Application No: FP/182/20/HH
Site Address: Gulls 7 First Avenue Felpham PO22 7LG
Description of works: Single storey rear extension to replace existing conservatory with revised roof to existing single storey extension, first floor rear extensions, single storey glazed canopy to south side elevation

Thank you for your internet representation made on 15th November 2020 which has been recorded as an objection with the comments as follows:

Job No: 3249
Dwg No: P_04

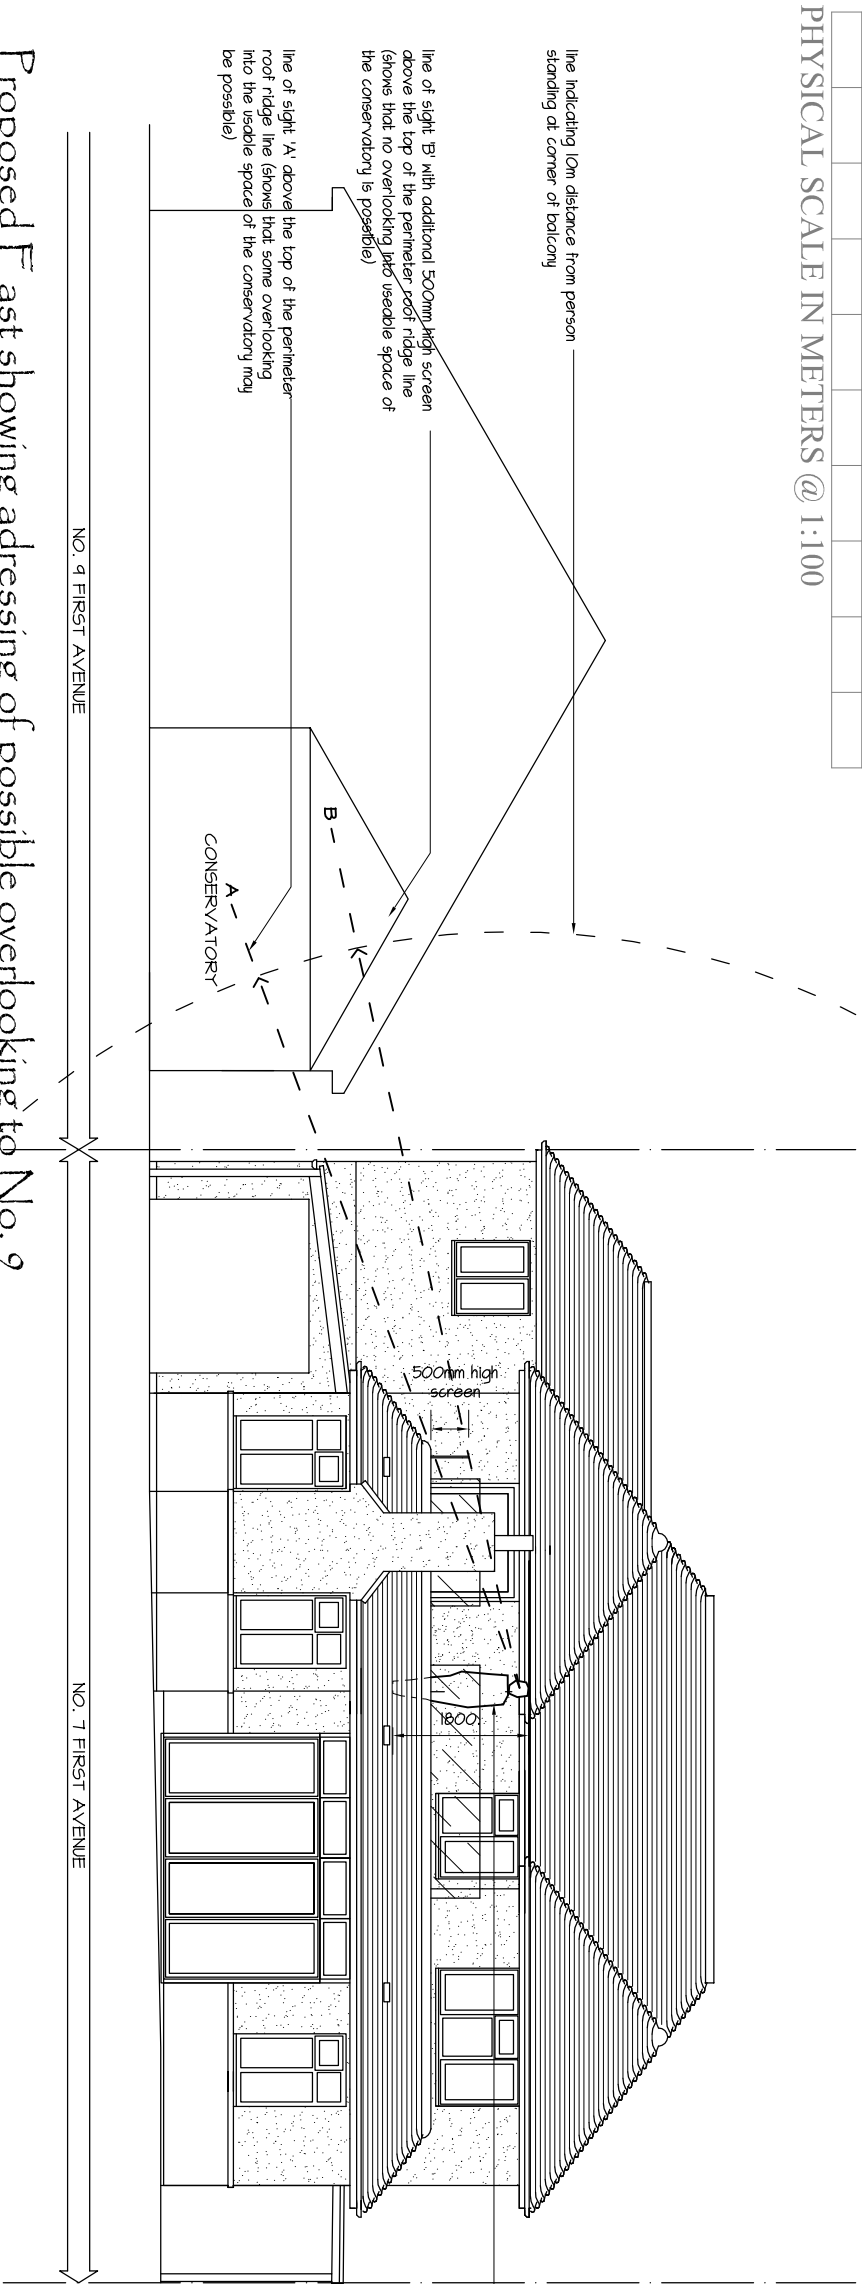
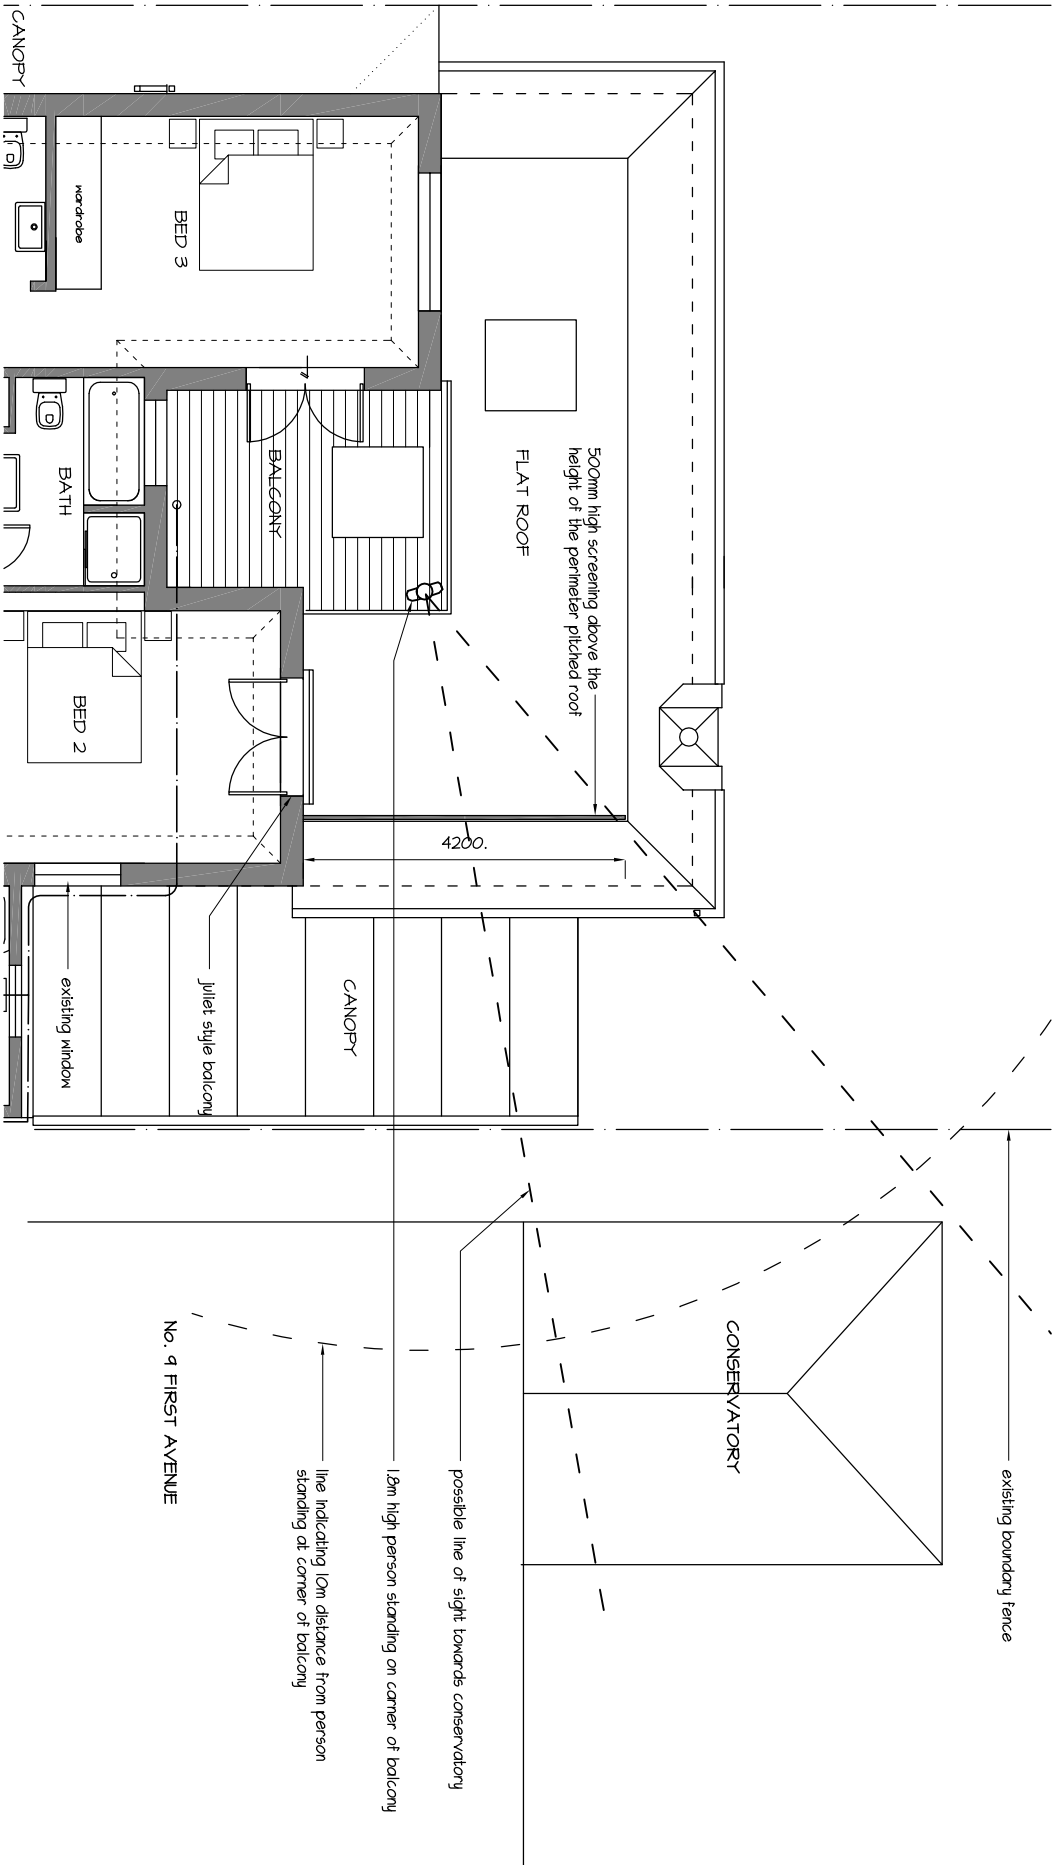
Having looked at the submitted planning application (ref FP/182/20/HH) and associated plans, I wish to place an objection on file as I believe the application contravenes Policy D DM1 of the adopted local plan. The plans indicate the construction of a first floor balcony and glazed balustrade. This balustrade on the south elevation is directly adjacent to my boundary and property and so this directly overlooks not only my garden but also directly into the living area of my house (bungalow), as I have a glazed roof on my conservatory. Given the proposed height of the balcony balustrading as indicated on plan, not only would one be able to see directly through this but anyone standing at the balcony would be able to look over and directly into my property and garden.
